**WELWYN HATFIELD BOROUGH COUNCIL
EXECUTIVE DIRECTOR - PLANNING, PUBLIC PROTECTION AND GOVERNANCE**

DELEGATED APPLICATION

Application No: 6/2018/1770/HOUSE
Location: 1A Northaw Road West Northaw Potters Bar EN6 4NW
Proposal: Erection of fence following removal of existing wall
Officer: Ms Lucy Hale

Recommendation: Refused

| 18-024-01 | | | |

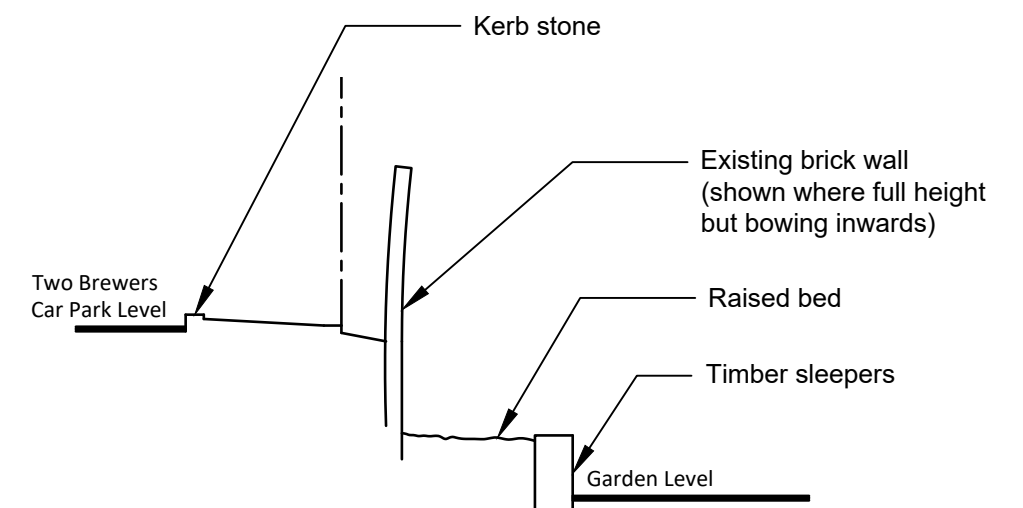
<p>The extension would reduce openness to some degree, given the increase in height of the boundary treatment, however, the harm to openness would not be significant. The site is located within a built up area of the Green Belt, in which boundary treatments are not uncommon. It is not considered that the proposal would result in material harm to the openness.</p>
<p>Design (form, size, scale, siting) and Character (appearance within the streetscene)</p>	<p>Section 16 of the Listed Buildings and Conservation Areas Act states that the local planning authority shall have <i>“special regard to the desirability of preserving the building or its setting or any features of special architectural or historic interest which it possesses”</i>. The specific historic environment policies within the NPPF are contained within paragraphs 184-202. <i>Paragraph 192 states that: “In determining applications, local planning authorities should take account of:</i></p> <ul style="list-style-type: none"> <i>a) the desirability of sustaining and enhancing the significance of heritage assets and putting them to viable uses consistent with their conservation;</i> <i>b) the positive contribution that conservation of heritage assets can make to sustainable communities including their economic vitality; and</i> <i>c) the desirability of new development making a positive contribution to local character and distinctiveness”</i> <p>Policy SADM15 of the Draft Local Plan Submission 2016 is in line with these aims. Furthermore, Policies D1 and D2 of the Welwyn Hatfield District Plan 2005 respectively require high quality design in all new development and for proposals to respect and relate to the character and context of their location.</p> <p>The proposal seeks permission for the demolition of the existing wall along the west side boundary and the erection of a 2 metre high fence adjacent to the car park of the Two Brewers Grade II Listed Building. The new 2 metre high feather edges boarded timber fence with concrete posts would extend 36 metres along the boundary, set back approximately 3 metres from the highway.</p> <p>The wall has partially collapsed as a result of damage and therefore needs replacing.</p> <p>The application site falls within a Conservation Area. The immediate area is characterised by permanent brick built boundary walls which run along the side and front boundaries of the properties along Northaw Road West. As such, this forms part of the distinct character of the area. The boundary wall, whilst partially collapsed, its position is highly visible from the streetscene and contributes to the character and appearance of the streetscene and this part of the Conservation Area.</p> <p>The proposed fence would be highly visible from the streetscene, when traveling down Northaw Road West, views of the entire 36 metre of boundary fence would be gained. As a result of the levelling of the land, the application site sits lower to the adjacent car park of the Two Brewers. When travelling up Northaw Road West, given its siting, the fence would appear of some height compared to the ground level of 1a Northaw Road West. The proposed fence in principle is not considered to be in keeping with the character of the permanent, brick built boundaries in the streetscene. Its siting as well as length and height, would form an incongruous addition which would be highly prominent and visible from the streetscene of Northaw Road West.</p> <p>The proposed design and materials are not considered to respect or relate to</p>

the character and historic fabric of the area. As such, the proposed fence would detract from the character and appearance of the site, streetscene and surrounding Conservation Area contrary to Policy D1 and D2 of the Welwyn Hatfield District Plan 2005, Policies SADM15 of the Draft Local Plan Submission 2016 and the NPPF 2018.
Impact on neighbours	The proposal would not result in any adverse impacts on the residential amenity of adjoining occupiers.
Access, car parking and highway considerations	The proposal would not affect the on-site car parking provision. In addition, the siting of the fence would not result in an impact on visibility or prejudice highway safety.
Conclusion	
The proposed development, by virtue of its height, siting, design and materials, would result in an incongruous addition which would be highly prominent within the streetscene and would detract from the character and appearance of the Conservation Area. The proposal is therefore contrary to Policies D1 and D2 of the Welwyn Hatfield District Plan 2005, Policies SP9, SADM11 and SADM15 of the Draft Local Plan Proposed Submission 2016 and the National Planning Policy Framework 2018.

1. The proposed fence, by virtue of its height, siting, design and materials, would result in an incongruous addition which would be highly prominent within the streetscene and would detract from the character and appearance of the Conservation Area. The proposal is therefore contrary to Policies D1 and D2 of the Welwyn Hatfield District Plan 2005, Policies SP9, SADM11 and SADM15 of the Draft Local Plan Proposed Submission 2016 and the National Planning Policy Framework 2018.
